**Consultation Response from: KC Environmental Health (Pollution & Noise Control)**
**2021/93921 - Former Midlothian Garage, New Mill Road, Holmfirth, HD9 7LN**
**Discharge of condition 16 (Validation Report (phase 1)) of previous outline permission 2015/93824 for erection of 56 dwellings and care home with associated car parking**
**Date Responded:**  
**27<sup>th</sup> May 2022**
**Responding Officer:**  
**Natalie Heaney**
**Responding Ref:**  
**WK/202138015**
**Condition 16 – Validation Report (Phase 1)**

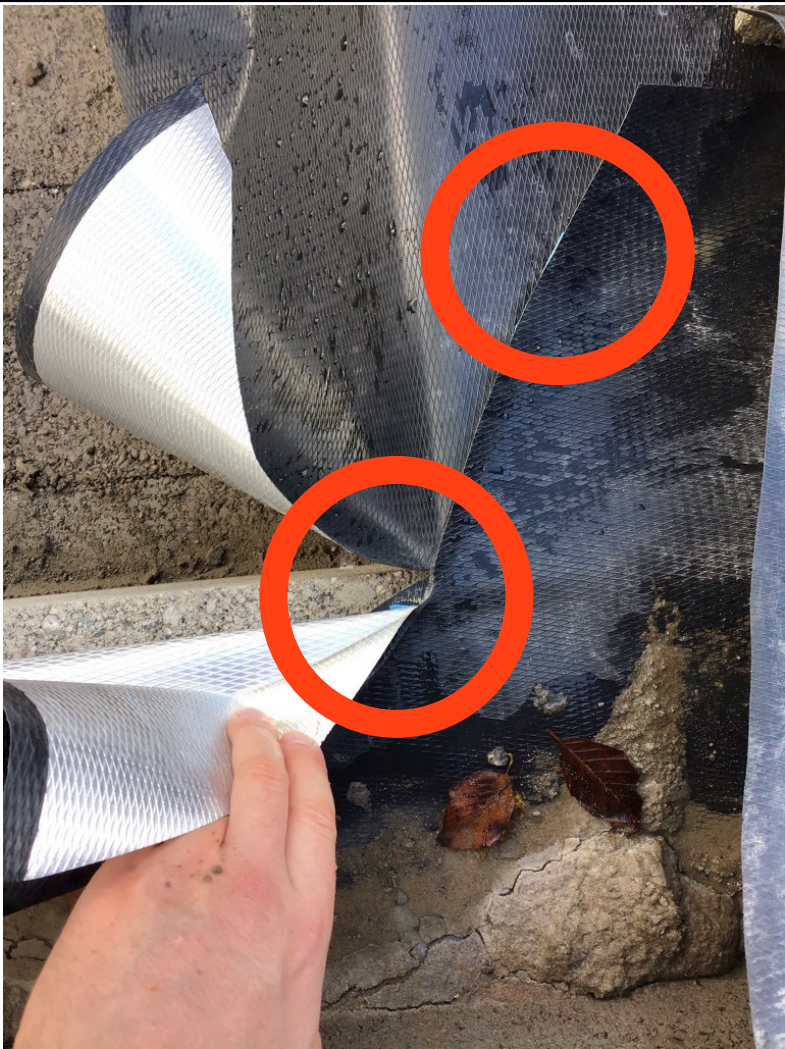
The Appendix B has now been provided in the validation report concerning Plots 14 to 21 (reference: SIG 3435 14-21). In the same appended information, the installation of the ground gas parameters for plots 16, 17, 20 and 21 are described. There are several references to the block work having been installed ahead of the validation visits. Further concerns are raised such as the double-sided butyl tape not always being visible and no DPC across the door thresholds. However, Geoshield consider these plots validated as they have assurance by an individual from Signature Homes that these were installed correctly. Lastly, the hexavalent chromium information and photo evidence of hardstanding that we previously requested has also now been provided.

Whilst several of our initial concerns have now been addressed, it remains that we have concerns over the installation of ground gas installation measures at plots 14 to 21 as this does not appear to have been verified in accordance with the agreed remediation strategy by Eastwood & Partners (reference: PR/AJK/39141-009).
